## R.W. Gillespie & Associates, Inc.

22 January 2021 (Revised)

Subject: Geotechnical Engineering Review of Gilman Street Temporary Support of  
Excavation Design  
Maine Medical Center Hospital Expansion  
Portland, Maine  
RWG&A Project No. 0557-031

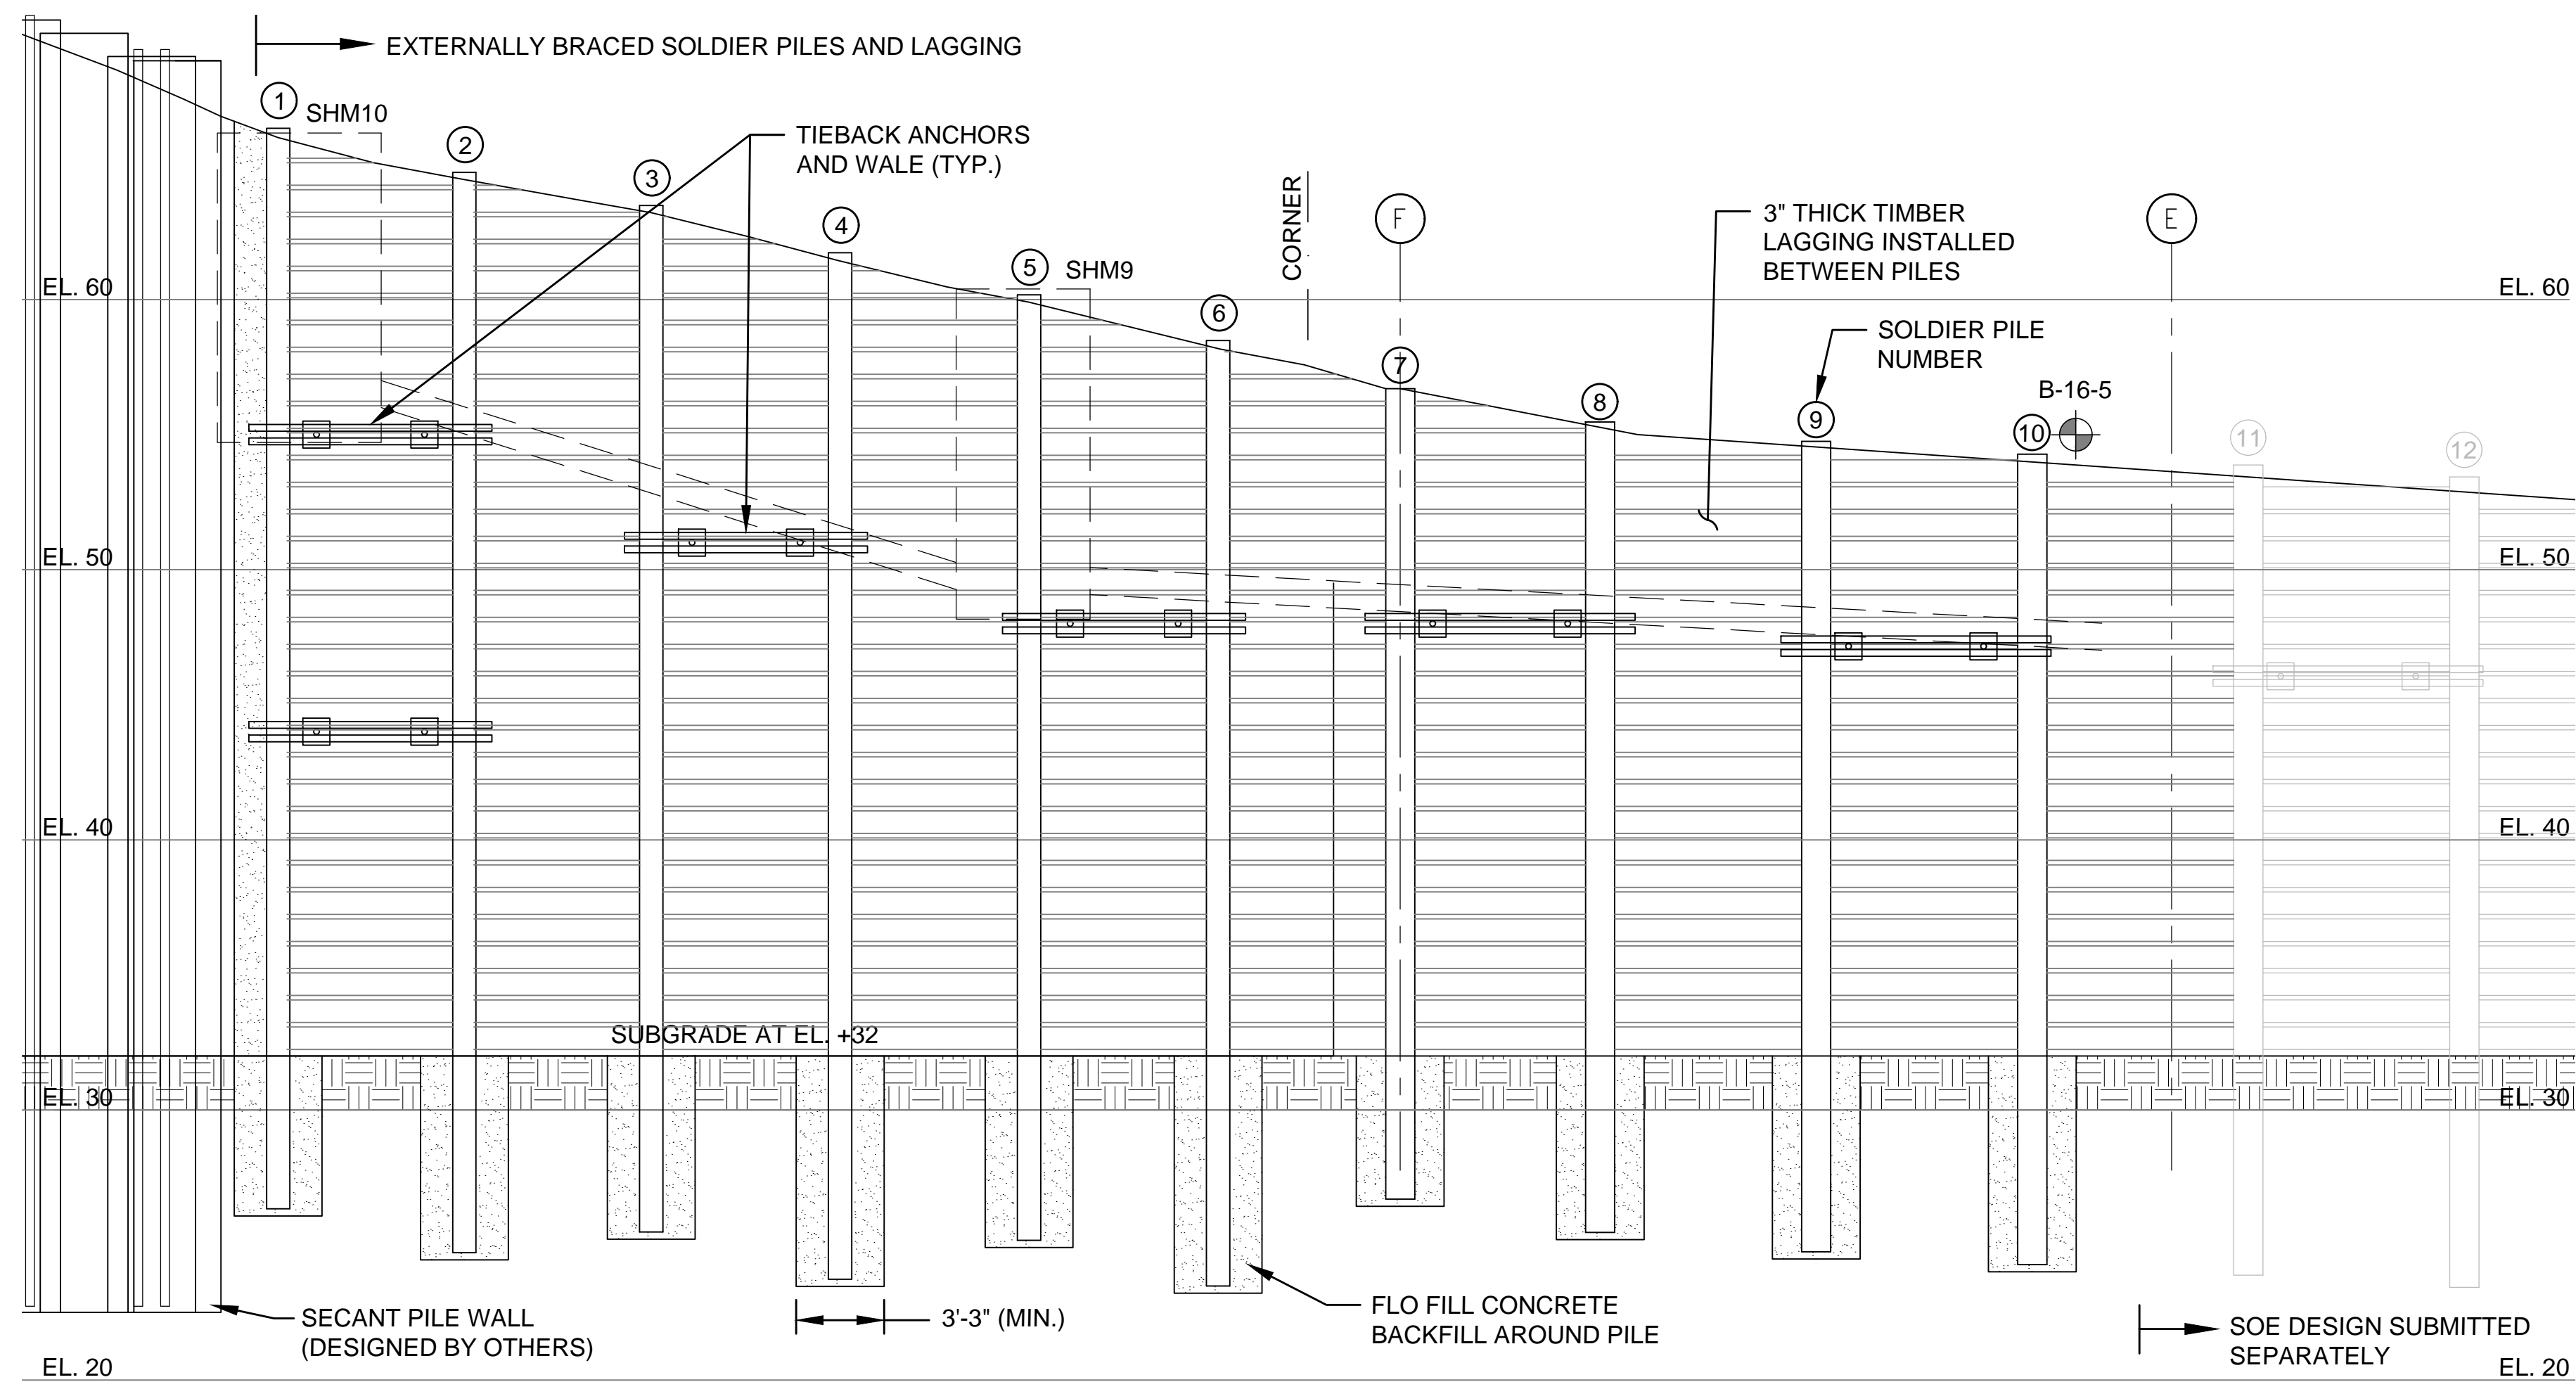
Based on the enclosed sketch titled *Section at Gilman St. Looking South Look South, Tieback 9 & 10*, the tiebacks would pass about 5 feet below an electrical duct bank, about 9 feet below a 6-inch waterline, about 5 to 7 feet below the bottom of SMH-8 and SMH-13533, and about 16 feet below a 4-inch natural gas pipeline at the west side of Gilman Street. The Contractor proposes to abandon four grouted soil tiebacks and four steel, H-shaped soldier piles in-place after the excavation between the SOE system and building foundation walls is backfilled. The H-piles are about 24 inches square in plan dimensions and would be surrounded by "flo fill" which we understand is a low-strength concrete. The sketch indicates that the "flo fill" and soldier piles would be removed to a depth 6 feet below the final grade after completion of foundation work.

Anchor Tieback Limits: The sketch prepared by Turner indicates that the Gilman Street right-of-way is 60 feet wide. The design calls tieback 65 feet long installed at a 20-degree downward angle. Based on the length and angle, the tiebacks would extend a horizontal distance of about 61 feet. It appears from the wale-to-pile connection detail that about 1 foot of the tieback would be located on the project side of the boundary, which would locate the end of the tieback very close to the Gilman Street westerly right-of-way boundary. If there are deviations from the design tieback lengths and inclinations, or in soldier pile positions, it is conceivable that the tieback might extend outside of the right-of-way and into the abutter's property.

*MMC should affirm that survey, construction, and design modifications are in place to assure that the tieback system will not extend beyond the westerly right-of-way boundary. The contractor should indicate how location, length, and angle control will be maintained and verified during installation.*
